Advice to decision maker on coal mining project

IESC 2017-092: Moolarben Coal Project – Optimisation Modifications (EPBC 2017/7974) - Expansion

Requesting agency	The Australian Government Department of the Environment and Energy, and New South Wales Department of Planning and Environment.
Date of request	3 November 2017
Date request accepted	6 November 2017
Advice stage	Assessment

Figure 6.4 - Forecast annual sediment dam overflows

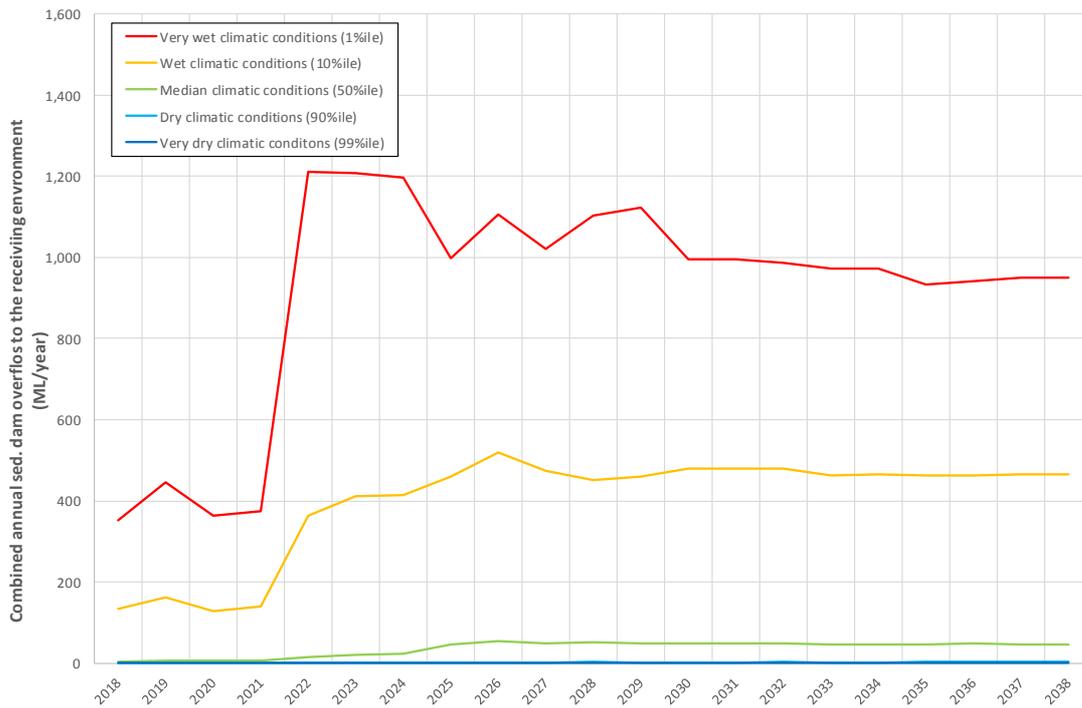
13. There are multiple proposed and existing water storage dams to control excess water on-site (EA App E, pp. 24-33). A period of reduced free capacity of water storages (2023-2027) coincides with the peak water production (2025). The total predicted uncontrolled discharges from sediment dams during this time are 1,200 ML/year in a very wet (1st percentile) climatic scenario, 500 ML/year for a wet (10th percentile) climatic scenario, or 50 ML/year for a median climatic scenario (EA App. E, p. 71).
14. Although the proposed increase to controlled releases will help reduce the likelihood of uncontrolled releases, uncontrolled discharges of up to 1,200 ML/year may still have impacts. The

EA does not adequately assess the potential downstream impacts of large volumes of uncontrolled discharges. Previous IESC advices for Bylong mine (IESC 2015-071) and the Wilpinjong extension (IESC 2016-075) identified water quality from uncontrolled releases as being inadequately assessed, and the cumulative impacts of uncontrolled releases are not addressed in this EA. The proponent needs to assess the possible hydrological, water quality and ecological impacts to the Goulburn River of up to 1,200 ML of uncontrolled discharge, taking into consideration the cumulative impacts of uncontrolled discharge from the Ulan and Wilpinjong mines and the proposed Bylong mine.

**Figure 4.1: Plan View of HEC-RAS Cross-Section Locations**

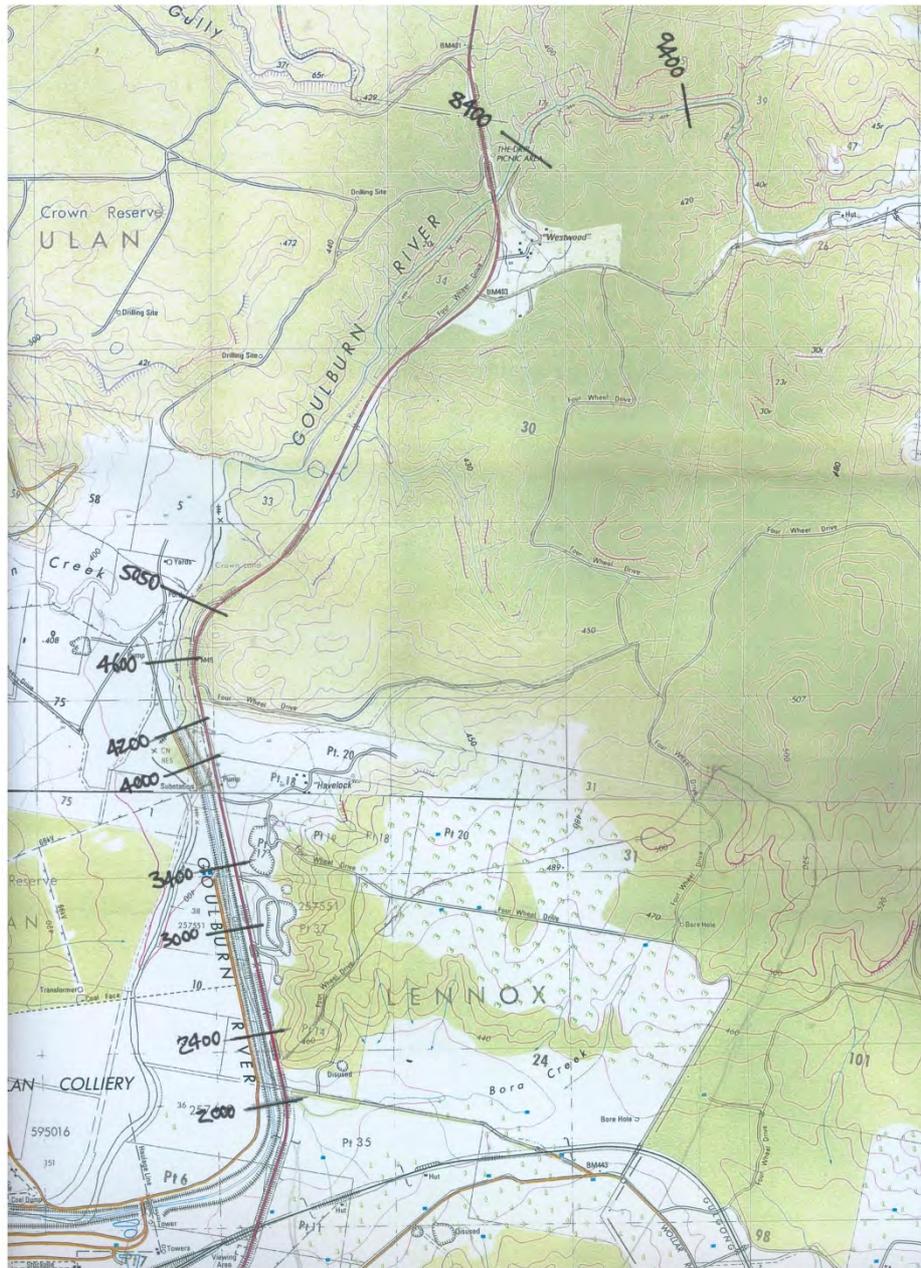
- c. Altered conditions that may favour the invasion and establishment of exotic species that impact upon native ones.
6. The proponent needs to assess the potential impacts of up to 20 ML/day sustained discharge on the Goulburn River (including the diversion channel), addressing:

- e. the capacity of the macrophyte beds to reduce turbidity of mine water discharge;
 - f. the potential geomorphological impacts (to sediment composition and depth) of up to 50 ML/day of cumulative mine discharge (from both Moolarben and Ulan mines) to the Goulburn River downstream of the diversion channel;
